Listed Building Consent for Alterations, Extension or Demolition of a Listed Building

Development: Listed building consent for the replacement of two windows on the ground floor at the rear of the house
Location: Elm Grove Cottage The Square Angmering BN16 4EA

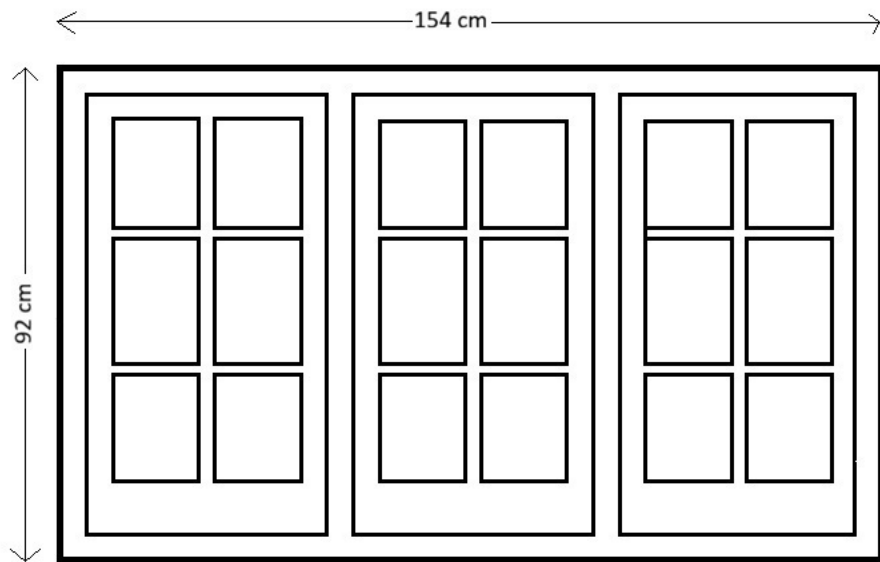
Please provide measurements, in metric, for the two drawings of the windows.
